**MERITON TOWER**

22 November 2011

**S.75W MODIFICATION TO MP10\_0057 – RESPONSE TO ISSUES  
132-138 KILLEATON ST, ST IVES**

DRAWING TITLE:
BLOCK A ELEVATIONS

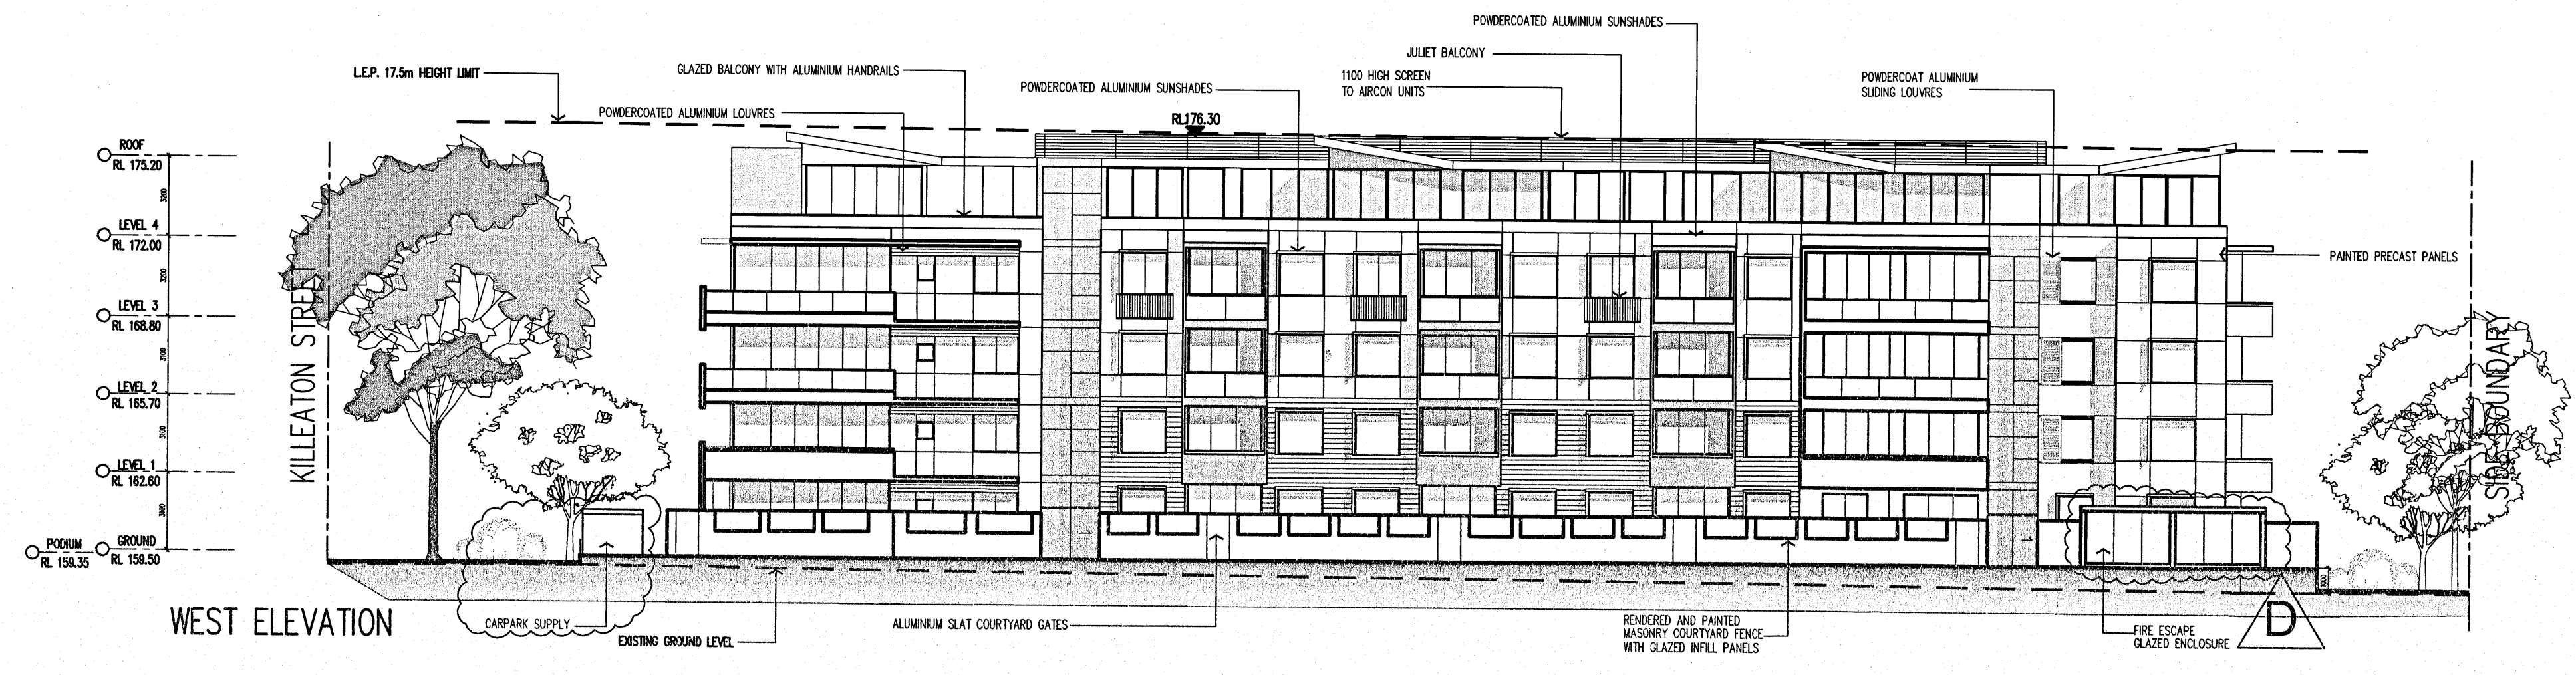
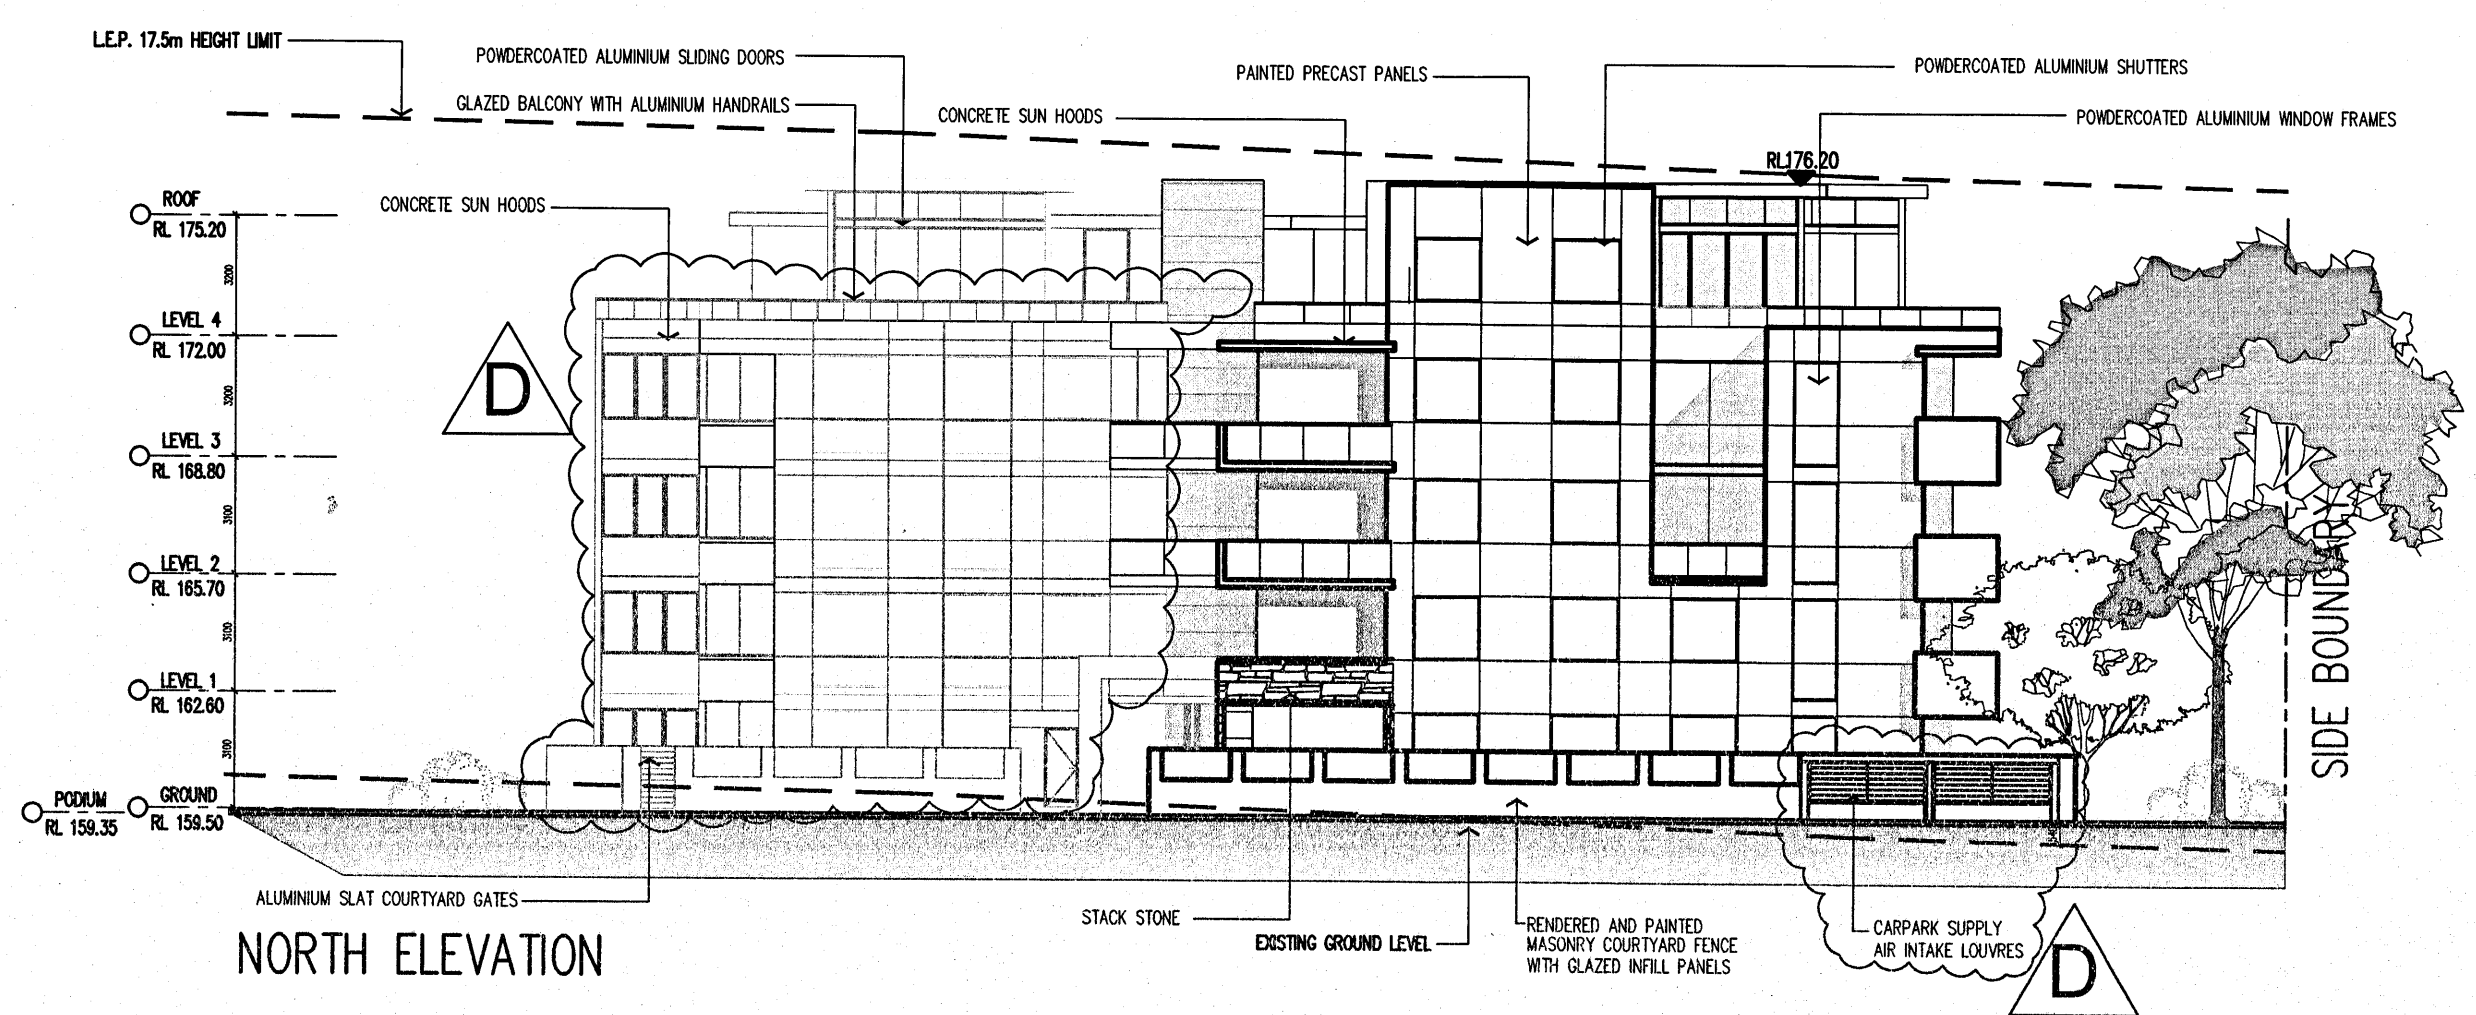
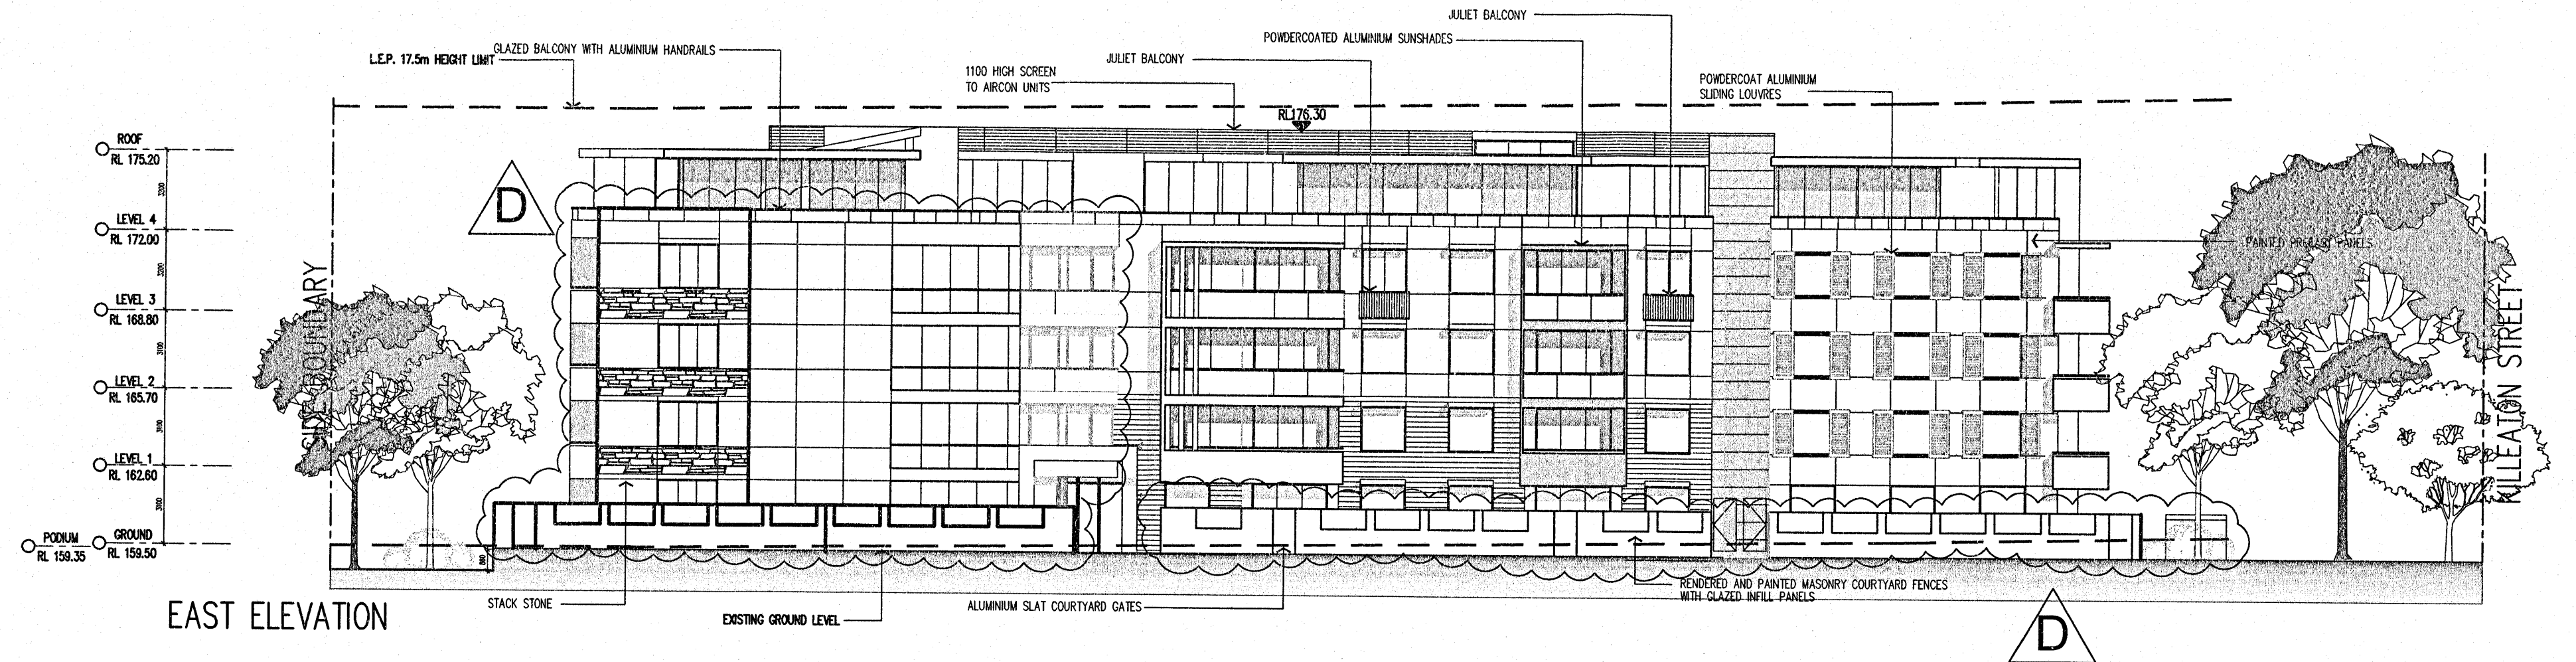
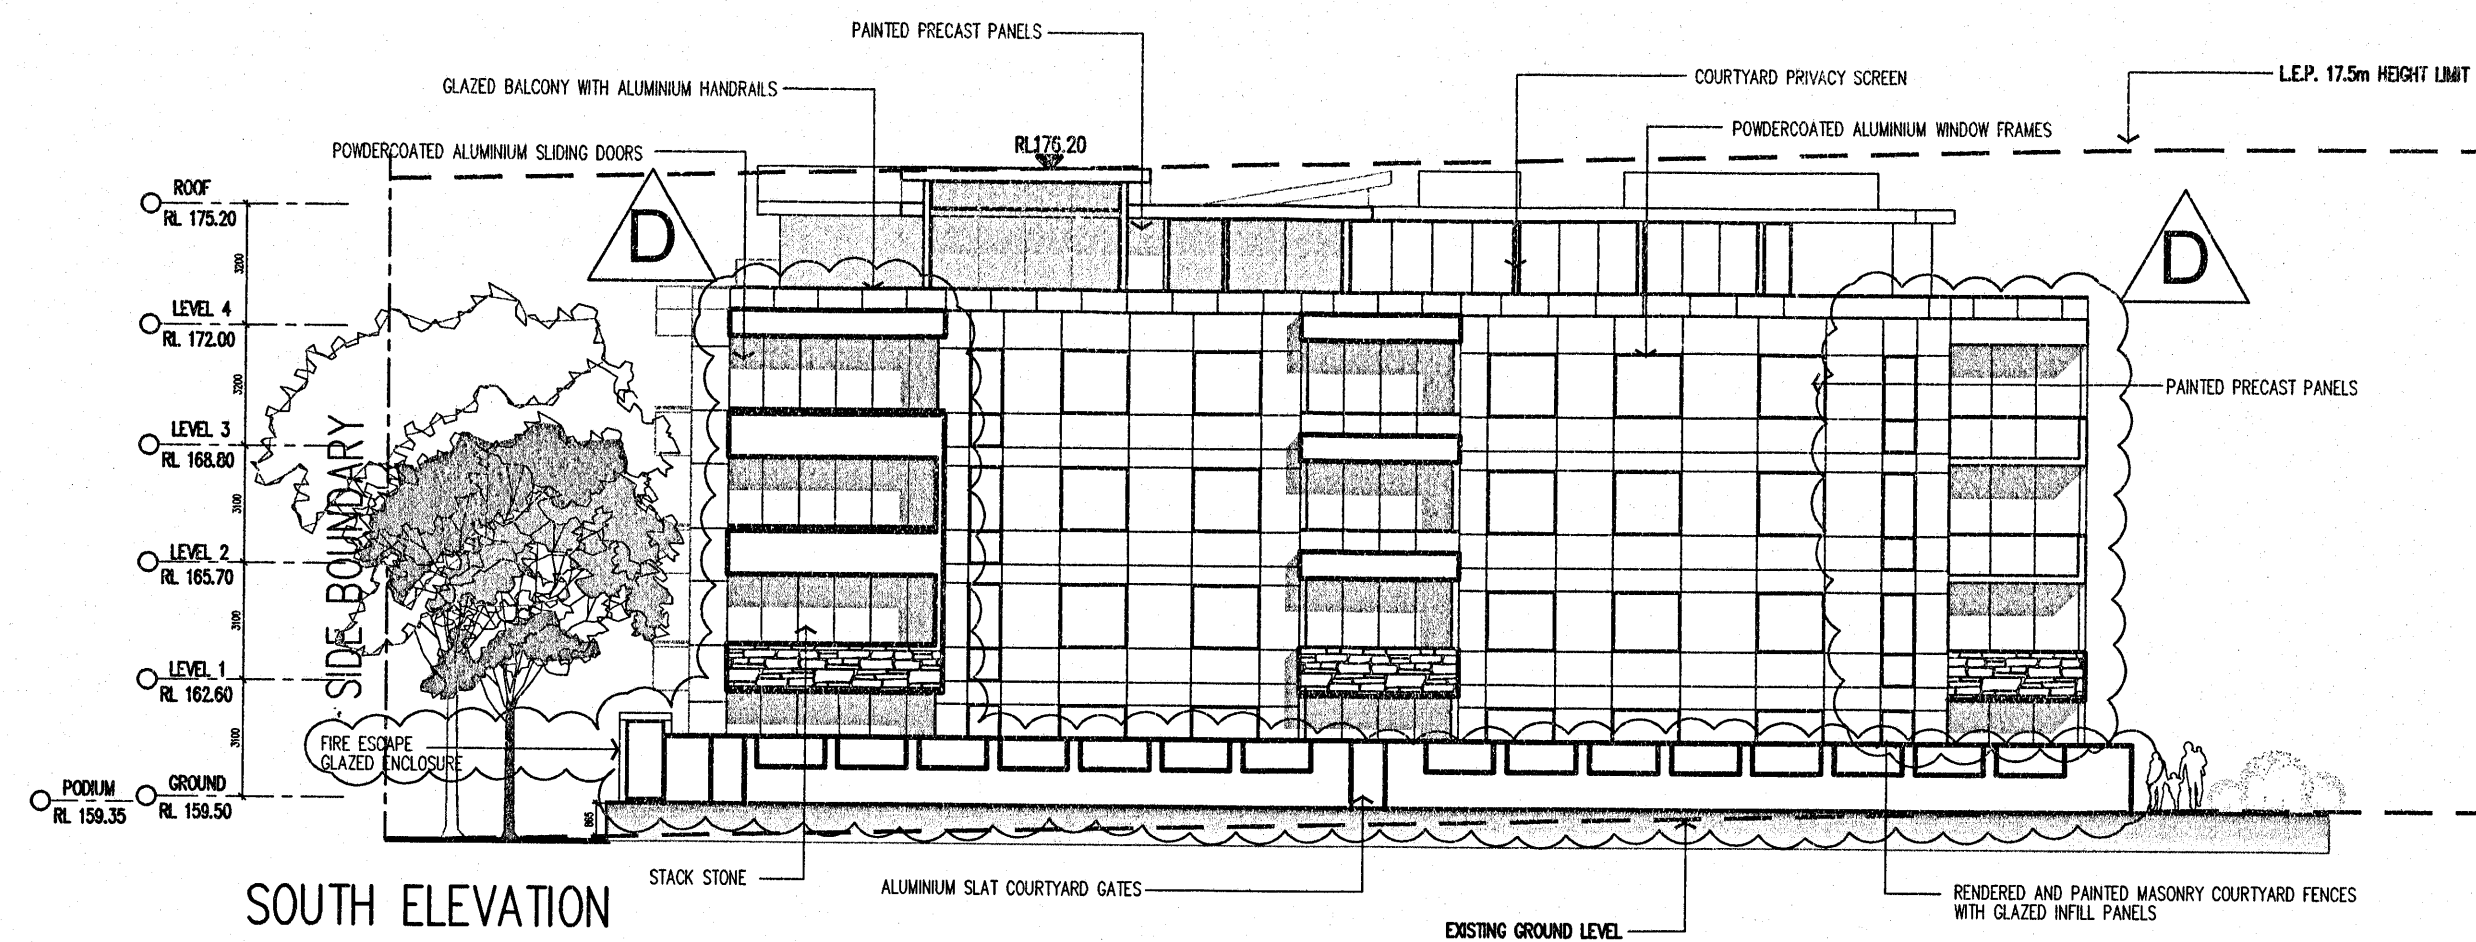
DA32 does not require any correction, as no additional pergolas are proposed to Block A.
